TO: Whom it may concern
FROM: Fiona Venn
SUBJECT: **Addendum to Lighting Technical Report for Modification 13 Planning Submission**
OUR REF: 181113-The Star-Mod 13-Lighting Technical Report-Addendum Rev 01
DATE: **13 November 2018**

The memorandum is an addendum to The Star-Mod 13-Lighting Technical Report, prepared by WSP, dated 31/01/2018.

This addendum responds to comments raised in the Request for Response to Submissions Modification Request 13 for The Star City Casino (MP 08_0098 MOD 13).

Special Lighting Events

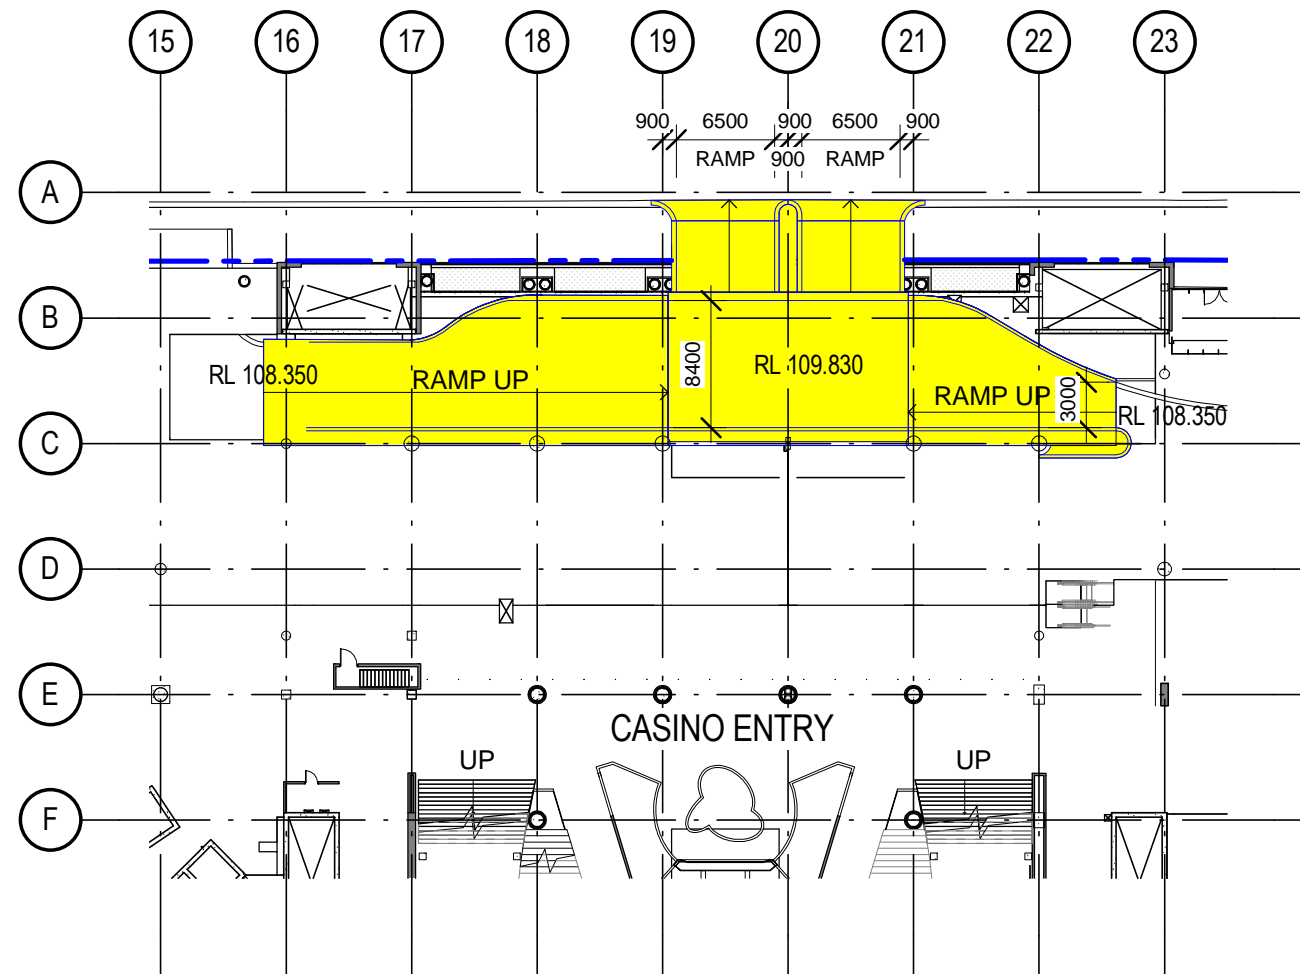
14. Provide additional justification for the total number of additional special lighting event (SLE) days, or revise the scheme to be consistent with existing limitations on other buildings within Darling Harbour. In addition, provide a consideration of the broader visual impact and light spill impact on the surrounding area.

'The area will now be subjected to moving projector lights, fixed on to the top of the Astral Hotel, and this will occur on at least 53 nights per year. This will add to the light pollution already emanating from the Star.'

The Star is recognised as one of Sydney's leading entertainment venues. Events and temporary light activations are regularly delivered within the venue. A special lighting event (SLE) has been staged every year, over twenty-one (21) nights, during Vivid Sydney since 2015. No issues or negative impacts have been reported in relation to the previous staging of the SLE installation.

As part of Modification 13, it is proposed that the temporary Vivid Sydney lighting installation become a permanent installation to highlight special events. It is also proposed that the SLE activation program be extended to cover thirty-two (32) additional event nights for a maximum of fifty-three (53) nights per year.

- Use of thirty-six (36) Sharpy light fixtures and thirty (30) LEP flood EX36 lighting fixtures located on the roof of the Astral Tower;
- All lights are programmed to be directed away from The Sydney Harbour Bridge, roads or any traffic or residential properties;

- All lights are aimed in an upwards direction only. The Astral Hotel’s roof structure obstructs the lights to the west, the SLE installation is aimed in an easterly direction only;

- The SLE is operational during curfew hours only – these are from 6:00pm to 11:00pm during Vivid Sydney. These are from dusk to 11:00pm on other event nights.;

- The SLE Light Show is operated on a half hourly basis and is on static (no movement) for the other half hour of each hour of operation;
- The SLE is designed in accordance with Australian Standard AS4282-1997 “Control of the obtrusive effects of outdoor lighting” and the Civil Aviation Safety Authority Regulations ‘Lighting in the vicinity of Aerodromes’;

The SLE is currently activated for twenty-one (21) nights per year as part of Vivid Sydney. The SLE will occur on an additional thirty (30) nights per year for a maximum of fifty-three (53) nights per year.

All SLE lights are programmed to be directed away from residential properties including 1 Murray Street. All lights are aimed in an upwards direction only.

The lighting to The Star, Sydney including the SLE is designed in accordance with Australian Standard AS4282-1997 "Control of the obtrusive effects of outdoor lighting".
